Project name	Slough Multifuel Extension Project
File reference	EN010129
Status	Final
Author	The Planning Inspectorate
Date	15 September 2022
Meeting with	SSE Slough Multifuel Limited
Venue	Microsoft Teams
Meeting objectives	Project Update Meeting
Circulation	All attendees

Slough Multifuel Project – EN010129

Section 51 advice regarding draft application documents submitted by SSE Slough Multifuel Limited

Works Plans

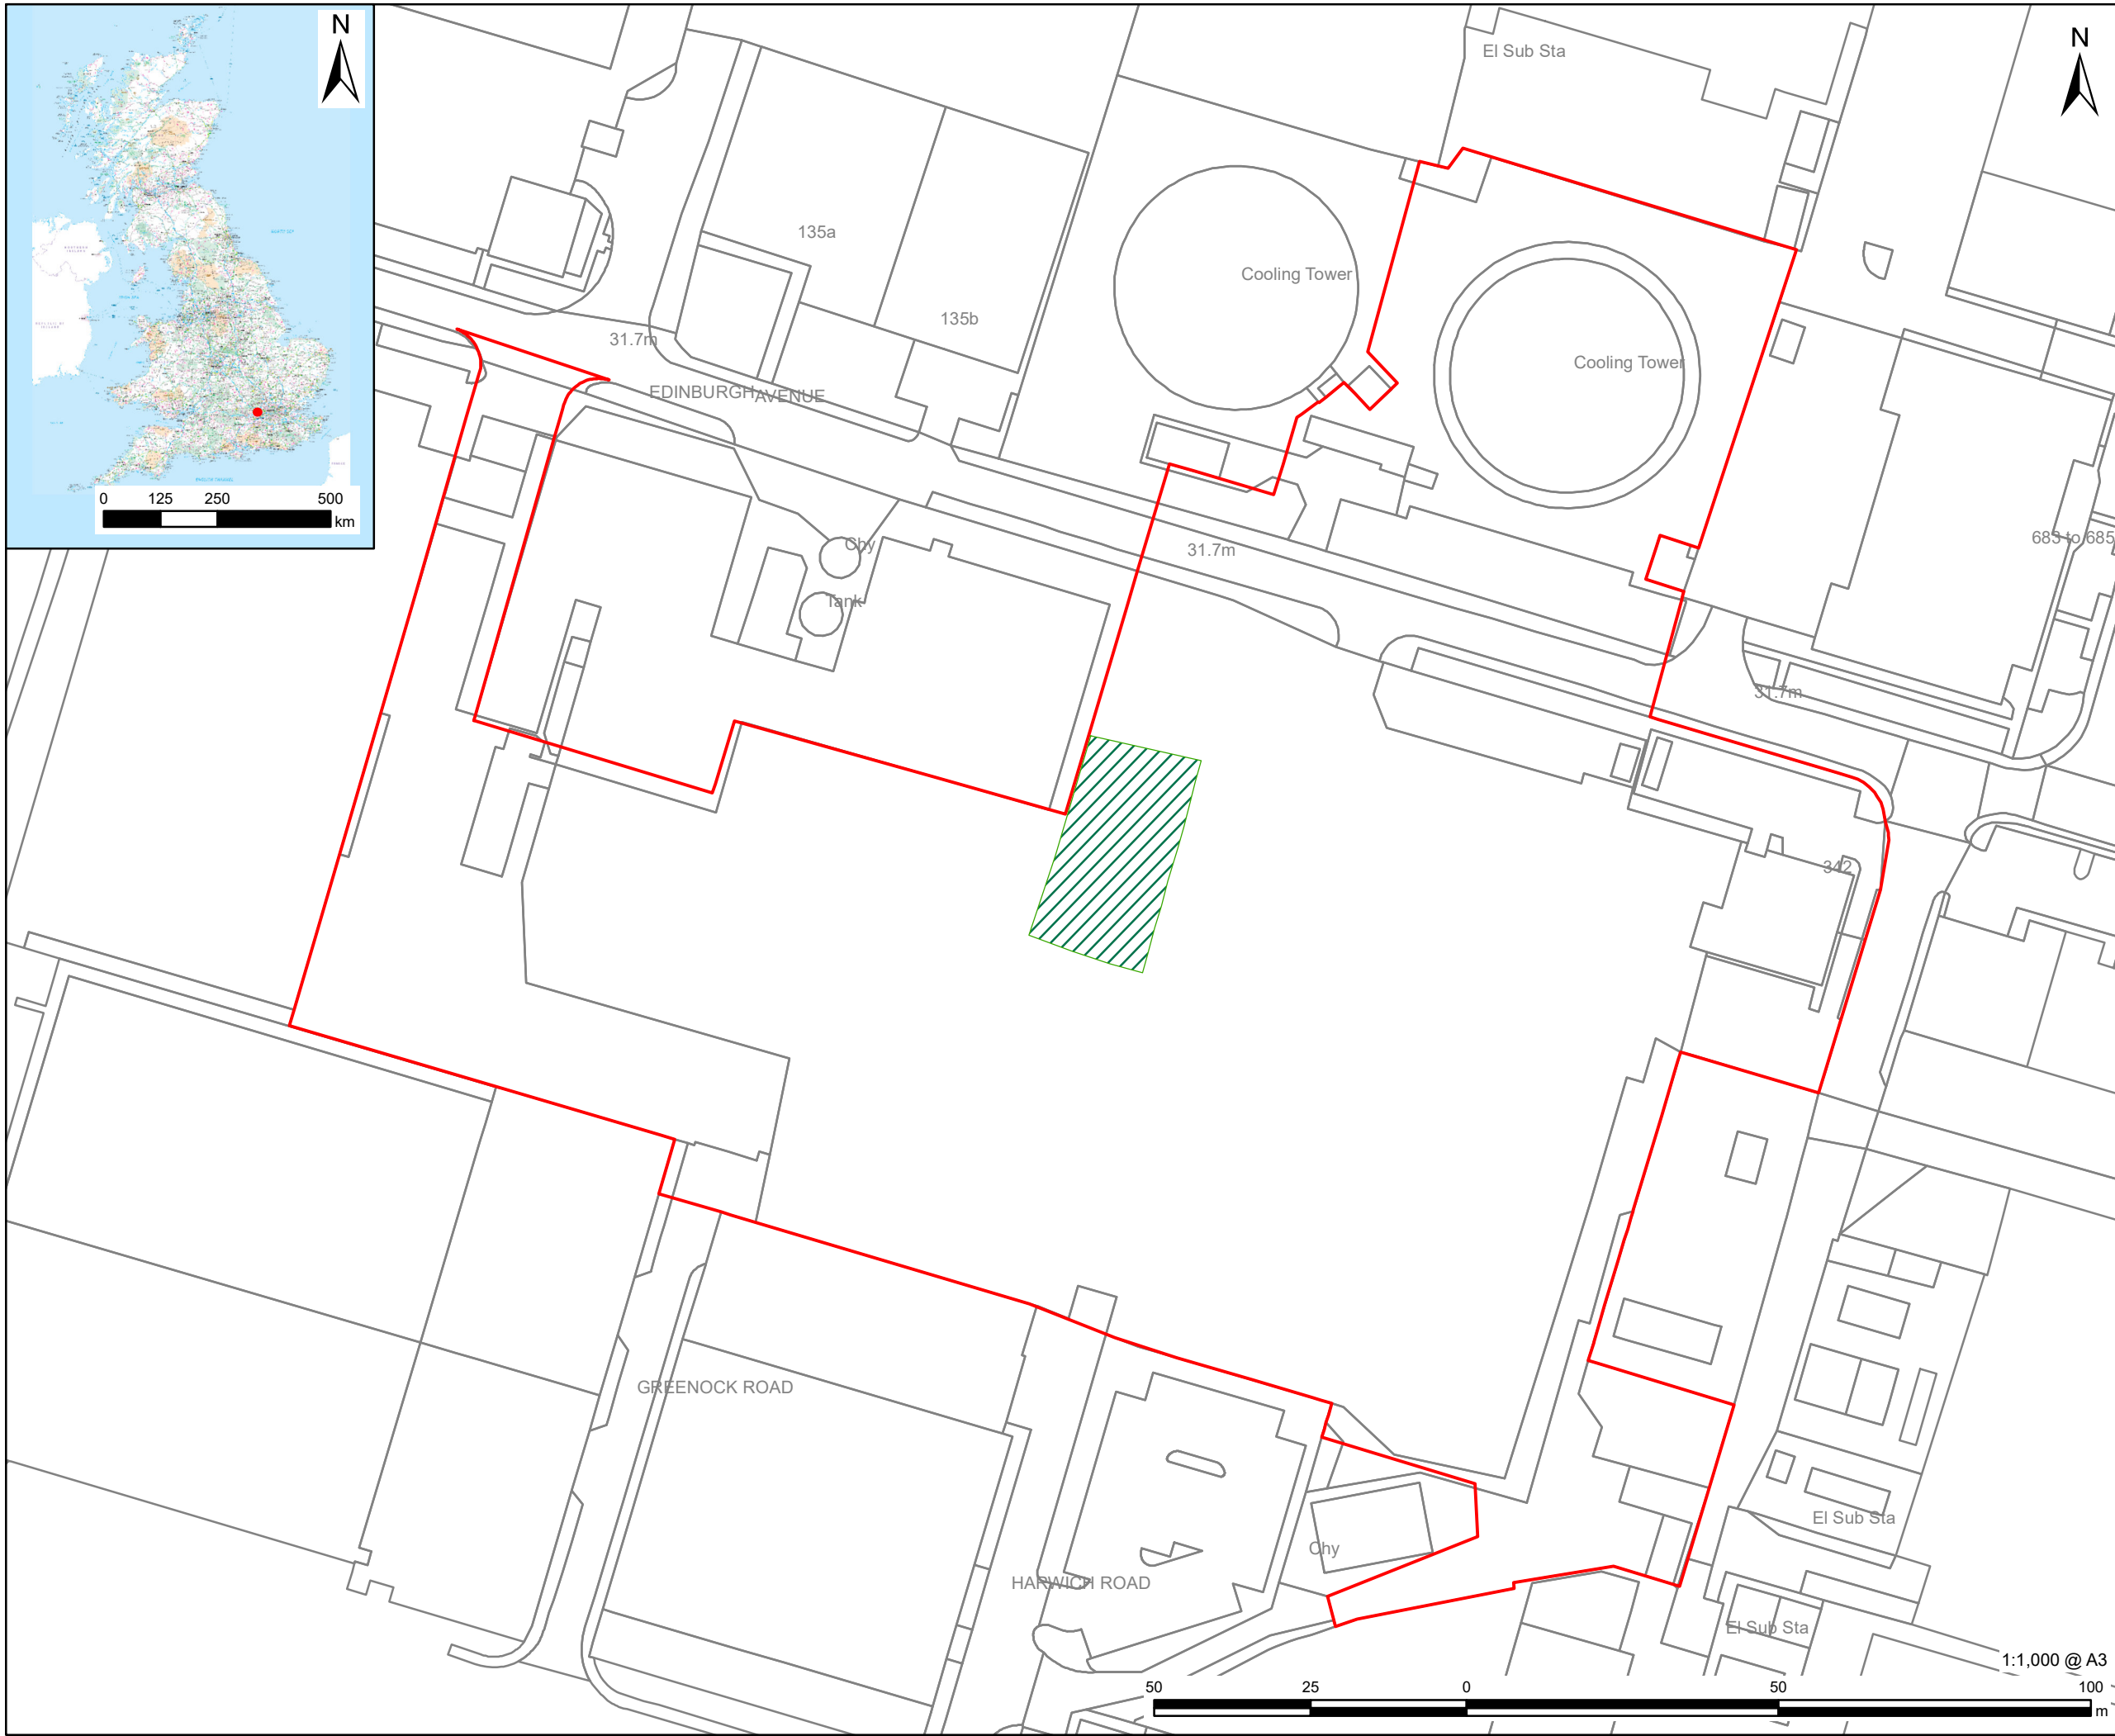
3.	Article 2(4)	(4) Unless otherwise stated, references in this Order to points identified by letters are to be construed as references to the points so lettered on the works plan. The Works Plan does not include any letters.

Works Plan		
Ref No.	Plan ref	Comment/Question
	Figure 4.4 Works Plan	See above re: Article 2(1) and 2(4)
		Helpful to provide a plan showing the Work No. 1 overlaid on the existing plans for the TCPA permission and further TCPA permission.

The Applicant confirmed it will provide an overlay to the Work Plan showing the details of the TCPA development and the location of the additional external pipe.
